September 12, 2016

**RE: Response to Comments - Level II Site Plan Application
Salvation Army Building Addition
88 Preble Street
Portland, Maine**

We have reviewed the City staff comments provided on August 31, 2016 for the Site Plan Application. Please find our responses to the comments below in *italics*.

**200**

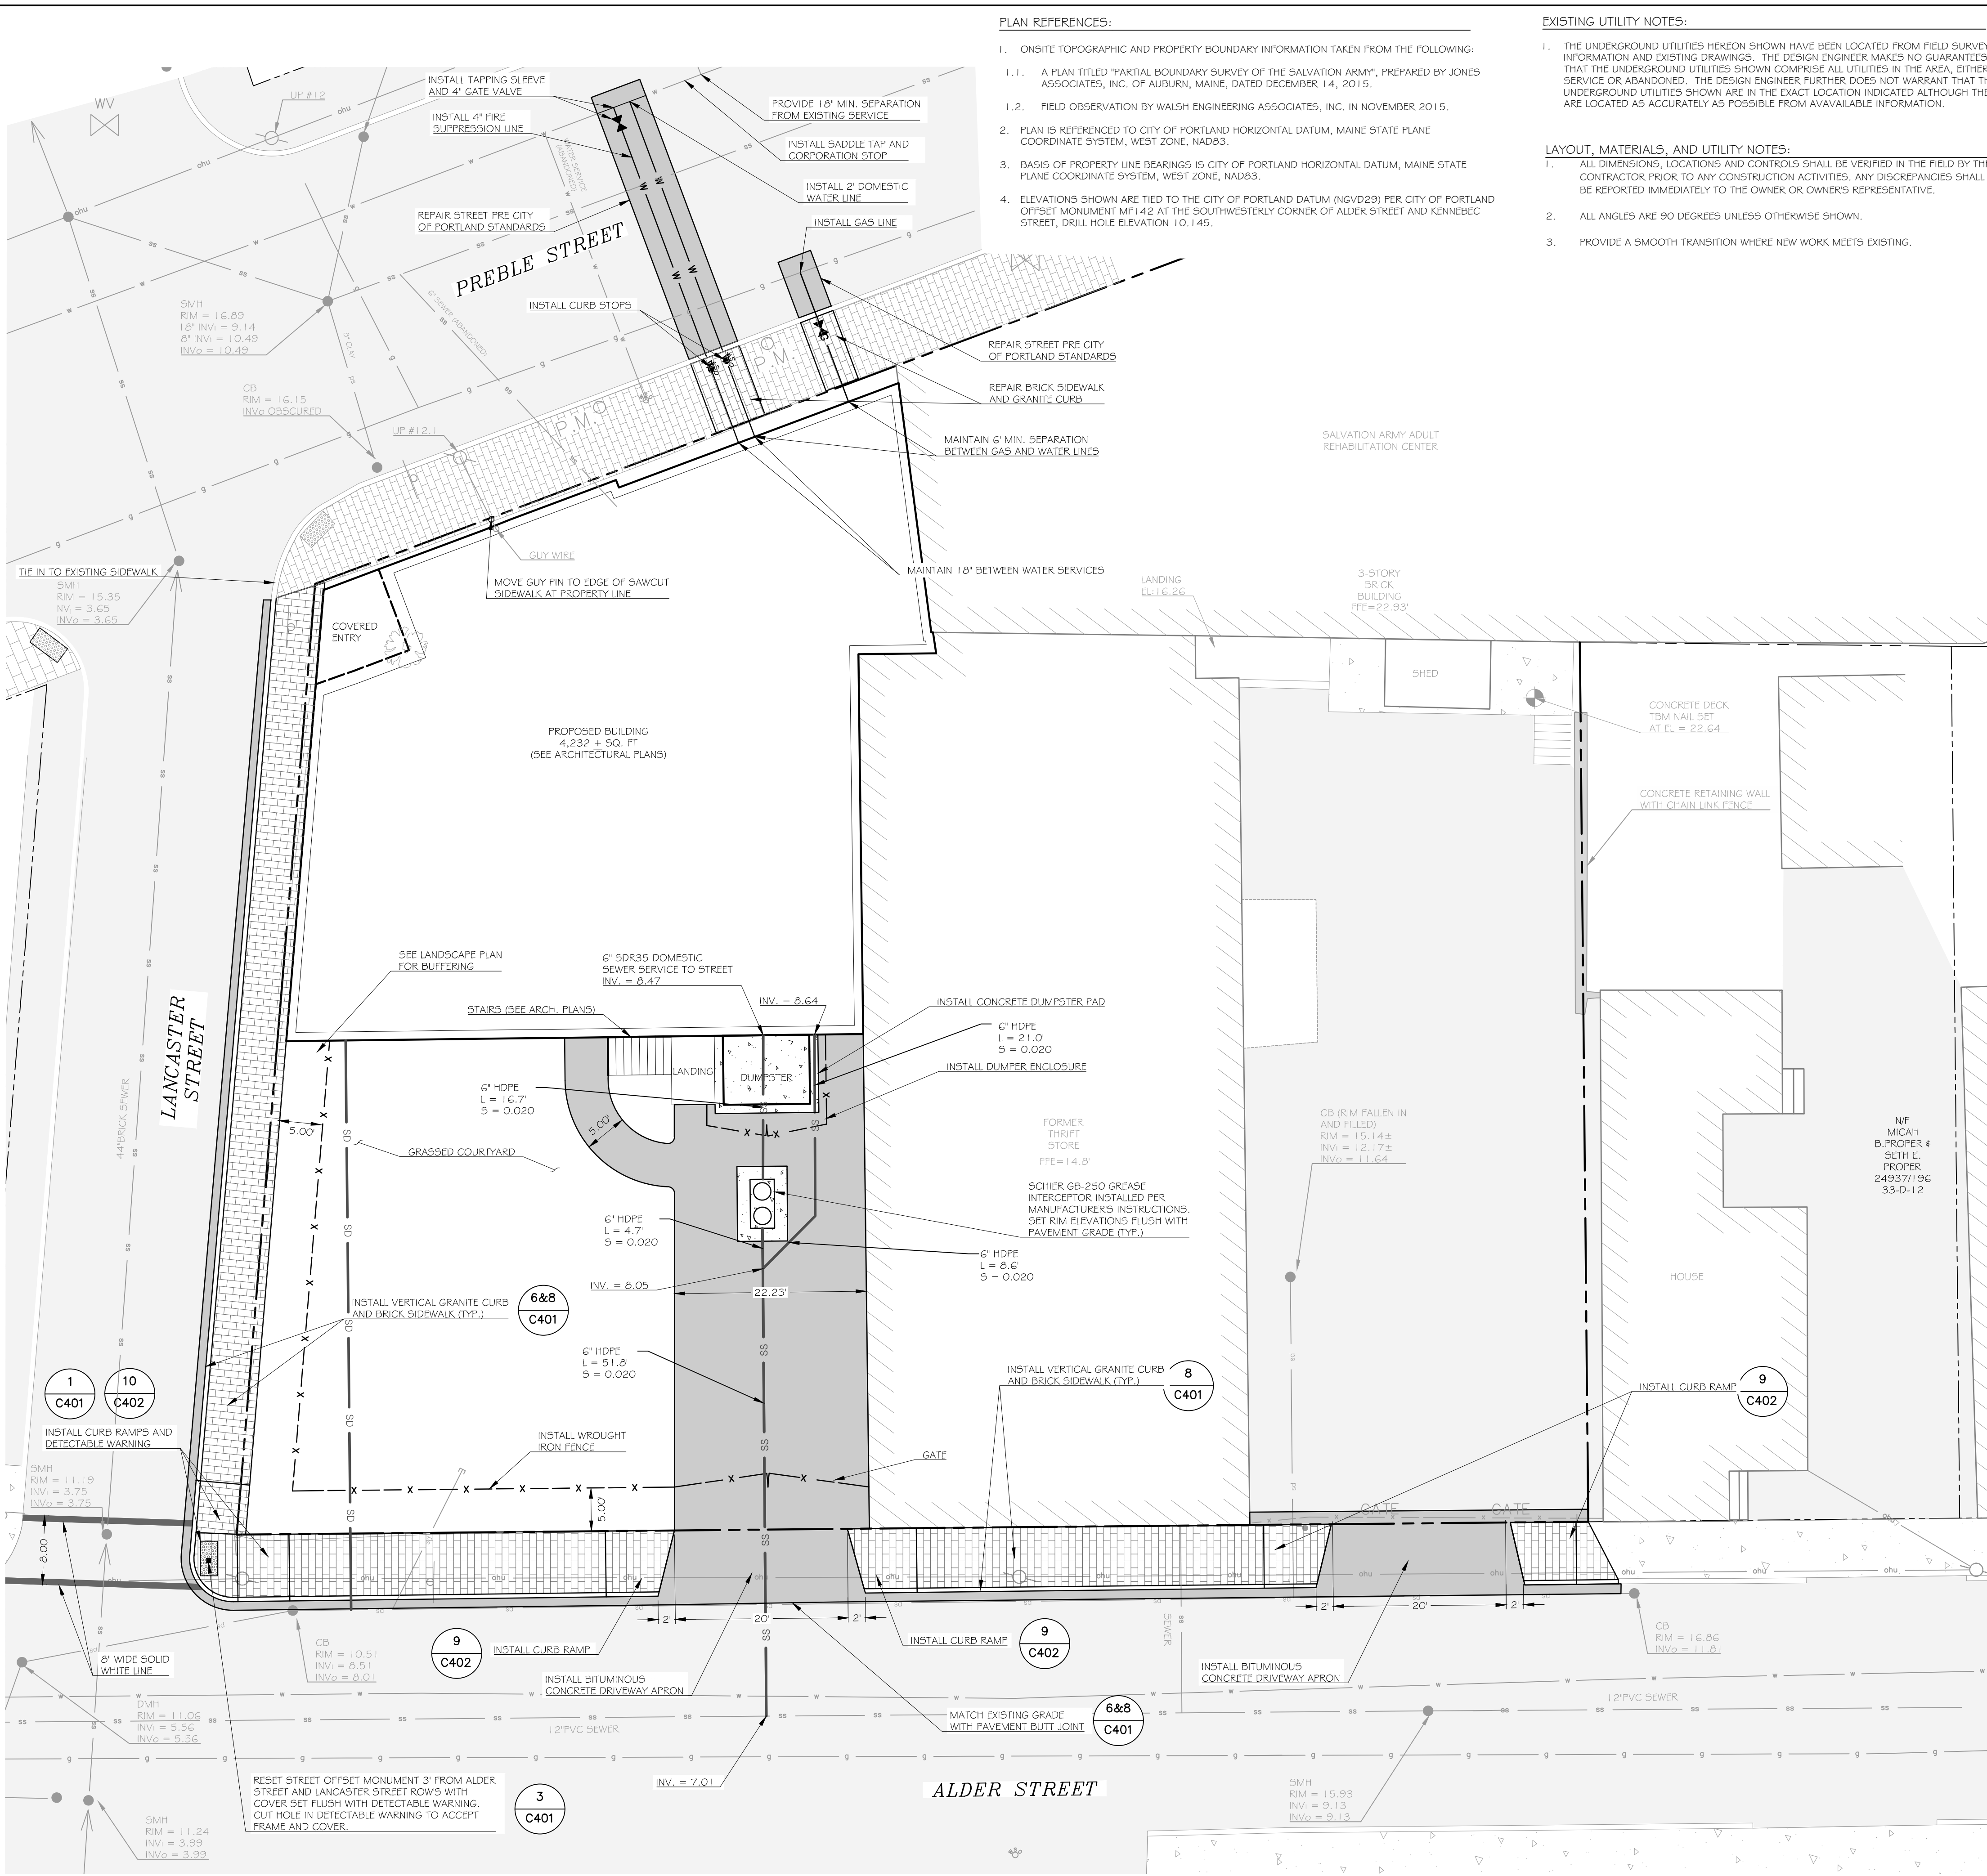
2. Specific details on a construction management plan shall be provided prior to construction for review and approval by City staff. I would note that a sidewalk facility, either the existing sidewalk or a temporary ADA compliant sidewalk in Preble Street along the project frontage shall be provided with approved barriers. Detouring pedestrians to the east side of Preble Street is not acceptable.

The selected contractor will provide a traffic management plan for review prior to commencement of construction, as indicated in Layout, Materials, and Utility Note 6 on sheet C200.

**10**  
C402 CURB RAMP DETAIL AT DRIVEWAY APRON  
NOT TO SCALE

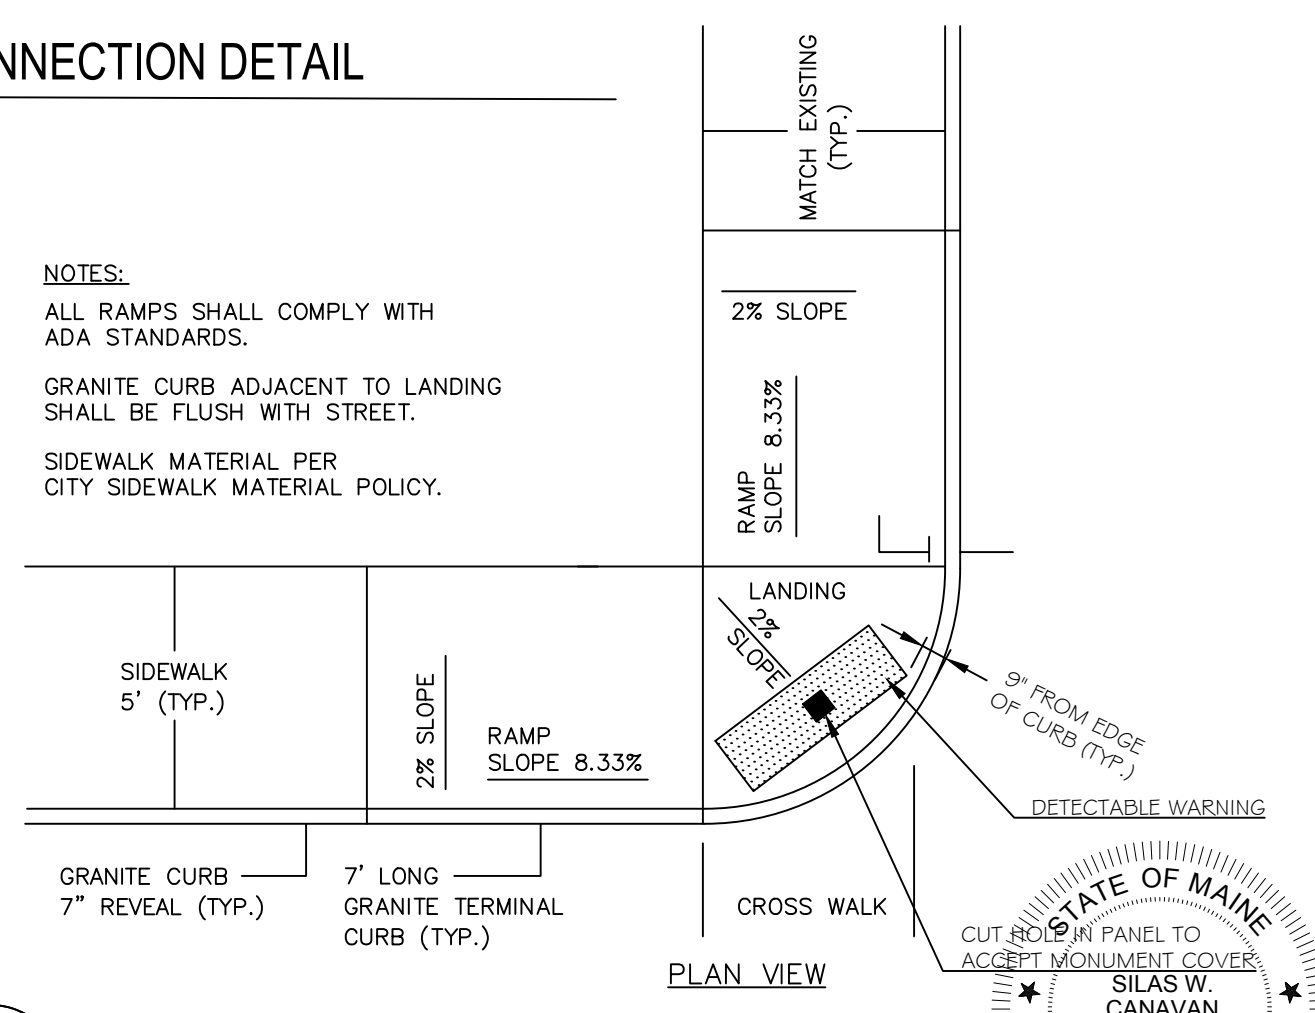
1. Bruce Hyman has provided design direction on the sidewalk ramps. The plans should be revised to reflect Bruce's Comments.

Detailed grading and additional notes have been provided at the curb ramps at the intersections of Alder Street at Lancaster Street and Lancaster Street at Preble Street (see Sheet C301) and at the driveway aprons (see Sheet C300). Given the site constraints, such as existing road grades and maintaining the existing catch basin inlet stones, it is structurally impractical to provide the standard grades at the Preble/Lancaster intersection as described in Mr. Hyman's comments. However, the grading requirements have been met to the maximum extent feasible, and have been improved from the existing conditions. Therefore, it is WEA's opinion that the proposed grading meets the requirements for alterations as described in 28 CFR 35.151
